Department of Primary Industries

OUT15/23020

**Dargues Reef Gold Project Modification 3 (MP 10_0054 Mod 3)
Response to exhibition of Environmental Assessment**

Dargues Reef Gold Project Modification 3 (MP 10_0054 Mod 3) Response to exhibition of EA Detailed comments – DPI Water

Figure 29: Stream flow sensitivity – Majors Creek % change

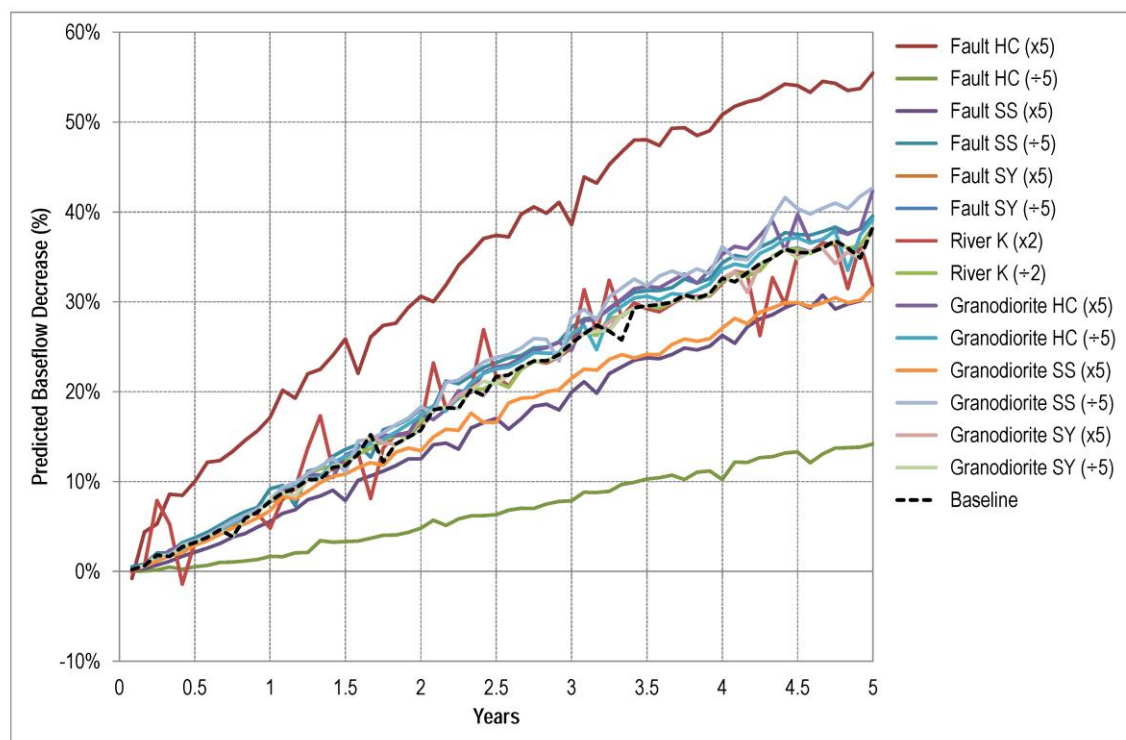
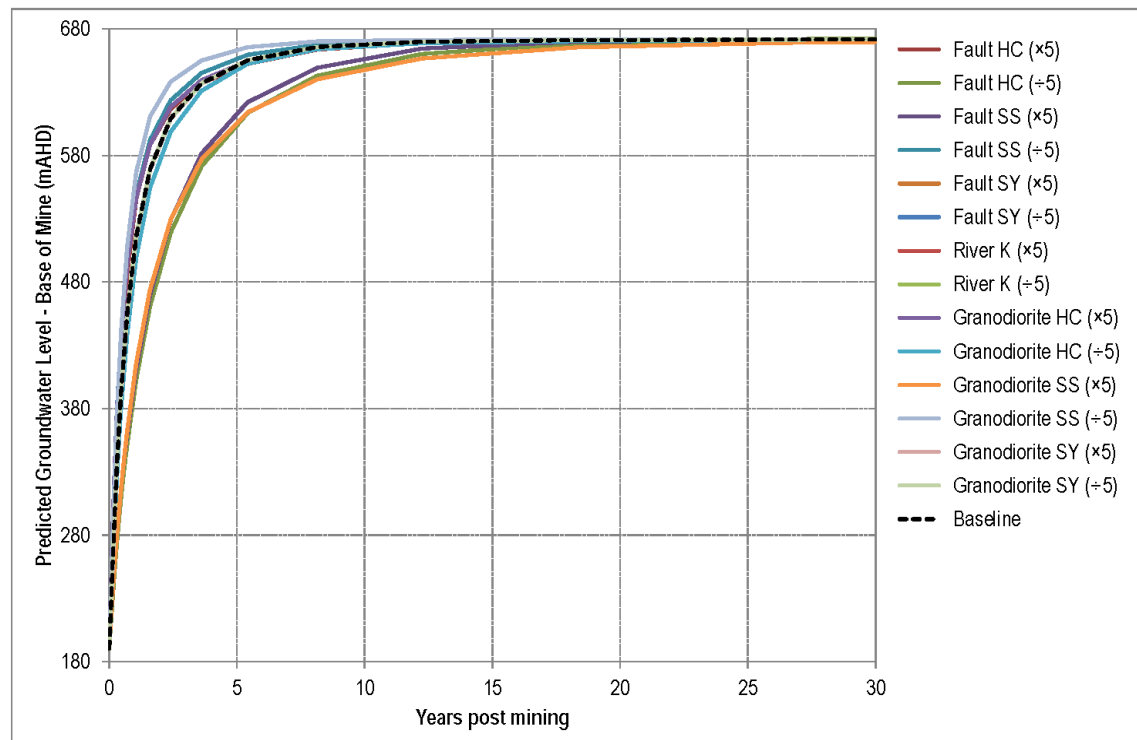
- The revised groundwater model predicts depressurisation to be less than previously predicted with no impact on private bores.
- The sensitivity analysis on the groundwater model indicated significant uncertainty in the fault hydraulic parameters used in the model. This results in the potential for significantly higher groundwater inflows than predicted and a resultant increased impact on baseflows to creeks. Additional data collection is recommended in the groundwater assessment (Appendix 10) to reduce this uncertainty.

- Uncertainty was recognised in the fault hydraulic parameters applied in the model and the report recommends that further data collection be used to reduce this uncertainty. This is critical as the report indicates that changing the faults hydraulic conductivity has the most impact on the baseflow to the lower section of Spring Creek and Majors Creek. This is illustrated in Figure 27 which shows the output from a sensitivity analysis where increases in the hydraulic conductivity of the faults generally doubles the predicted mine inflow. This therefore has implications to accurate baseflow impact predictions and compensatory flow volumes, and the potential water entitlement that will need to be held.

- The uncertainty of mine inflows from faults highlights the need to periodically review the groundwater model and validate predictions against impacts, in addition to considering the adequacy of mitigating measures and licensed entitlement. It is recommended a review of the groundwater model be completed prior to commencement of mining operations with the additional data collected since preparation of AGE (2013). This would be with the aim of reducing the uncertainty of mine inflows and associated impacts, and adequately informing preparation of the Water Management Plan and potential licensing requirements.

The proponent shall update the Groundwater Model with all available measured groundwater and surface water data prior to commencement of operations. This plan must be developed in consultation with DPI Water.
